Application Reference: 2026/0448

Site Address: 15 Wentworth Crescent, Penistone, Sheffield, S36 6ES

Introduction: This application seeks full planning permission for the removal of detached garage to side and erection of single storey rear extension, rear dormer and infill to front recess to dwelling.

Client Martin and Vicky  
 Project 2657 : 15 Wentworth Crescent : Domestic Extension  
 Title Existing and Proposed Elevations

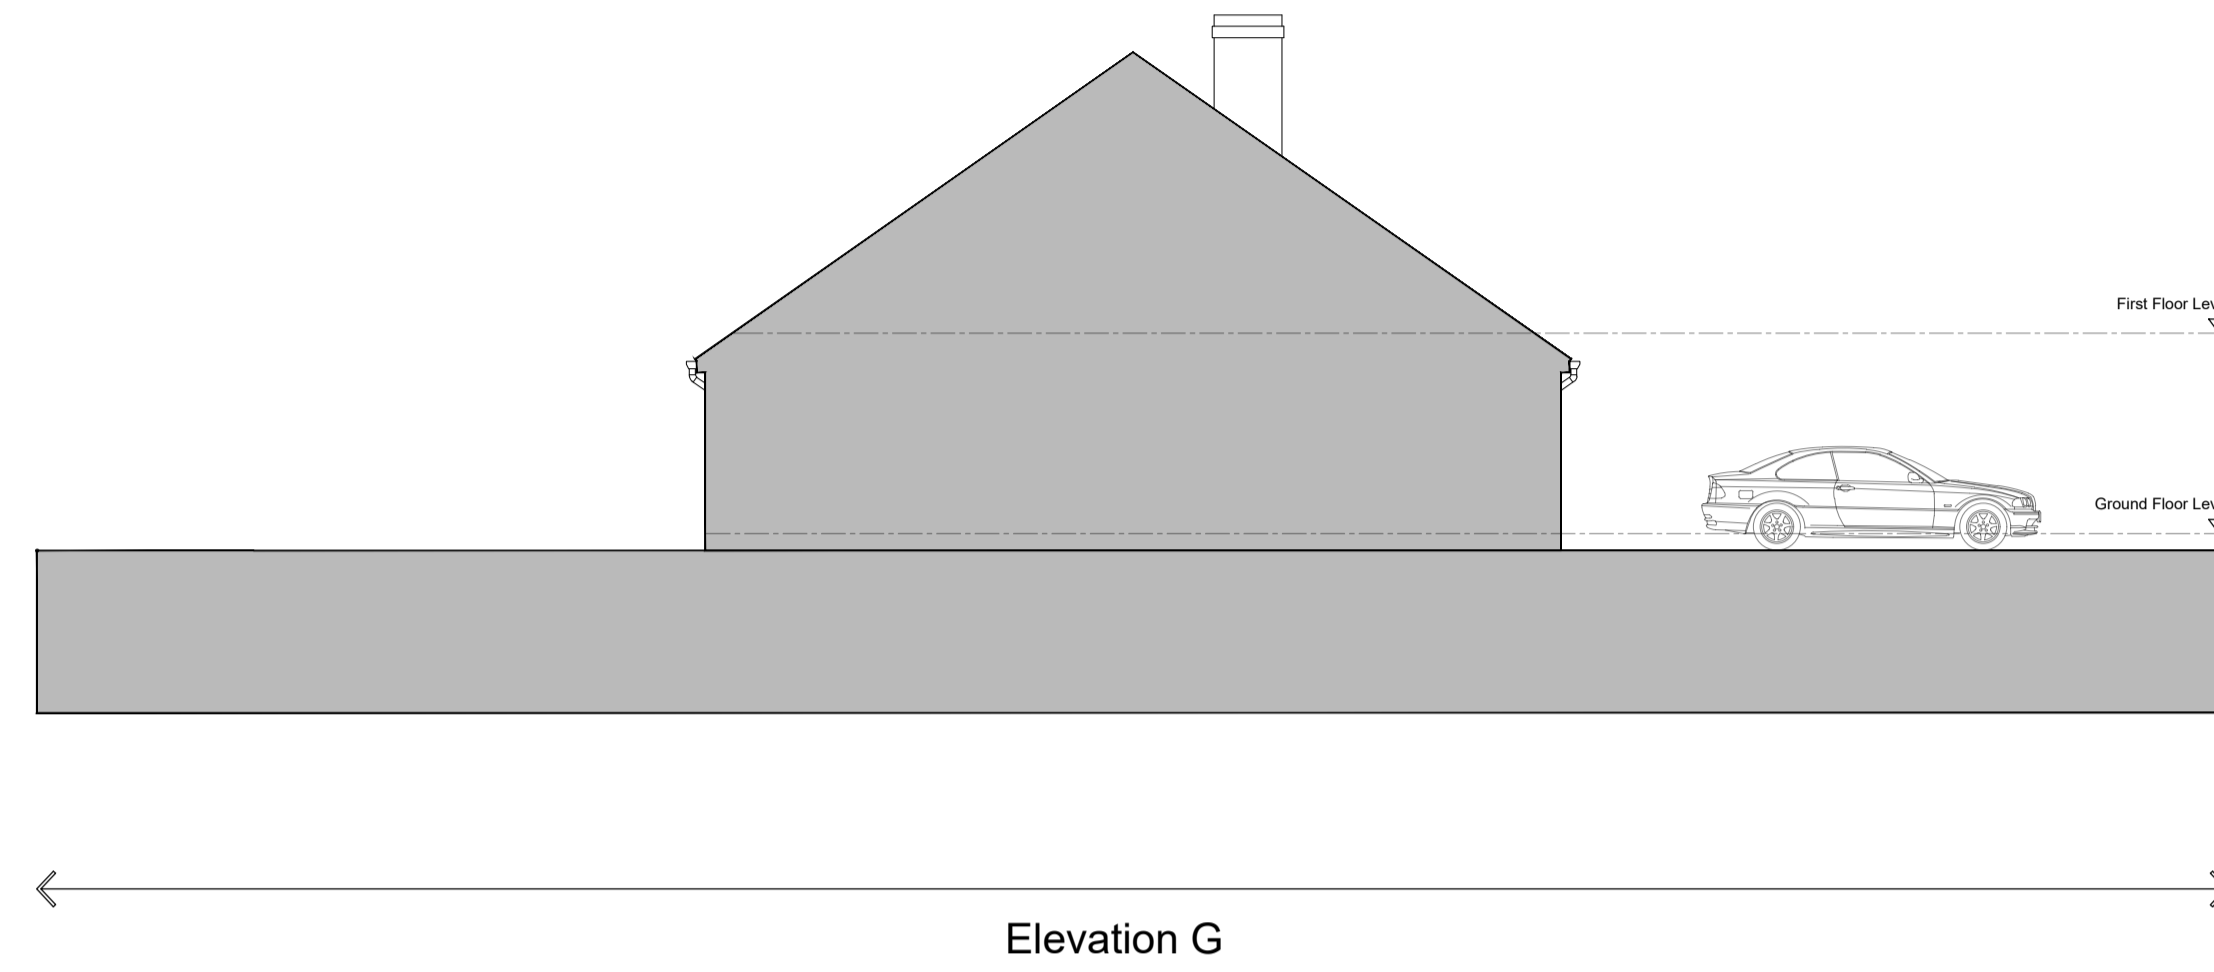
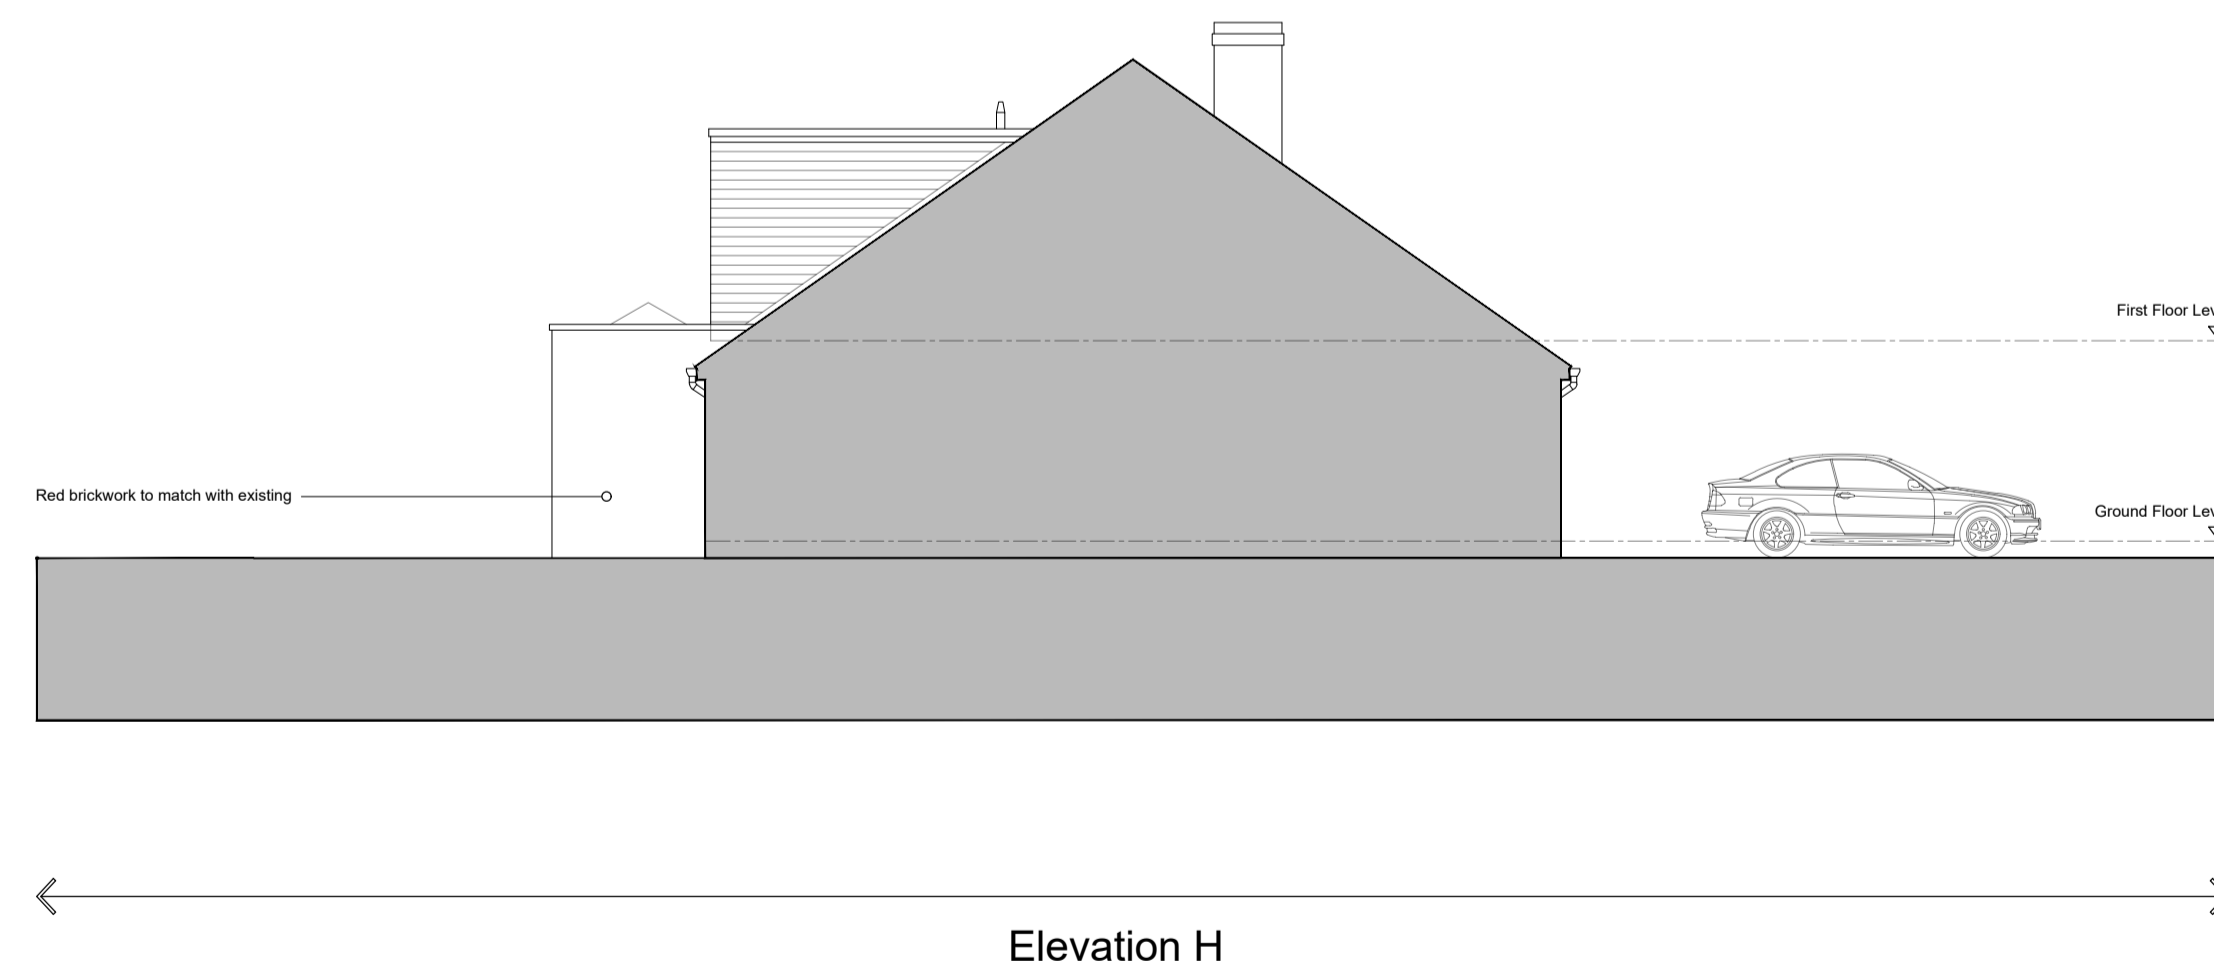
The approximate 2.3m rear projection of the proposed ground floor rear extension, which also practically extends across the whole width of the rear elevation, is less than the 3m usually allowed through permitted development. However, with an approximate flat roof height of 3.10m, which is also higher than the existing eaves height of approximately 2.64m, and with a roof lantern extending to about 3.38m, the proposal does not meet the height requirements for permitted development, with this type of roof. For a planning application, whilst the eaves should not usually be higher than the existing eaves, the main roof is also being altered, but not heightened, and it is the rear elevation, not the principal front elevation, so would not be as impactful within the street scene as if it was constructed on the front elevation.

The proposed addition of a relatively large rear dormer does not affect the height of the existing roof, which remains with a ridge height of approximately 6.8m. Like the rear extension, the size of the proposed dormer at approximately 36 cubic meters, may have been eligible for permitted development. It would again though be the modified eaves height of the dwelling, and potentially the proposed composite cladding not being of a significant enough similar appearance to the materials used within the existing house which would disqualify the proposed dormer as eligible for permitted development.

Whilst the scale of the proposed rear extension and dormer, are both acceptable, the design of the dormer is not strictly in accordance with SPD guidance. For dormers which require planning consent, the SPD House Extensions and Other Domestic Extensions states a preference for pitched roof dormers, constructed with hanging tiles to match the roof. For this application, the proposal is for a box dormer featuring grey composite cladding. Whilst in essence this differs from SPD guidance, box shaped dormers are prominent features on bungalows across the borough, and increasingly are constructed with composite cladding, also frequently grey in colour. Whilst it is uncertain if bungalows within the street scene have rear box dormers, an adjacent, almost identical bungalow sitting below the application dwelling on Hall Gate, along with another detached bungalow on Hall Gate feature rear elevation box shaped dormers.

The proposed infill within the front elevation of the dwelling, along with relocation of the principal entrance door onto the front elevation would potentially provide the most significant change to the design and character of the dwelling. If the front door had already existed on the front elevation, then the infill, at less than 3 sqm, may have qualified as permitted development. Whilst the proposal does potentially improve the design of the application dwelling, the counter effect of unbalancing the symmetry of the pair of semi-detached bungalows and the combined trio of similarly designed pairs of bungalows on the street must be considered.

With just an approximate 2.3m rear projection, even without the consideration of what may be considered as acceptable through permitted development, its size would have a limited impact on the amenity of No 13. The 45-degree is technically breached, with a 0.04 sqm corner of the extension potentially breaching a 45-degree angle from the centre of the closest ground floor window of No.13. However, the scale of breach is too insignificant to consider it having any noticeable impact on the amenity of No 13. With a relatively low roof height of 3.10m, excluding the roof lantern, the height of the extension would also have a limited impact on amenity.

Regarding the proposed dormer, there are no neighbouring dwellings it would overlook, and in addition to not directly overlooking the garden of No 13, the boundary line between the application dwelling and No 13 is angled in the favour of the application dwelling, widening the garden of the application dwelling and narrowing the garden of No 13 as it progresses from the centre of the pair of dwellings. Therefore, the dormer indirectly overlooks more of the applicant's garden than it would No 13.

Clarification of material choice and colour of the composite cladding for the rear dormer was requested but no amendments to plans were required.
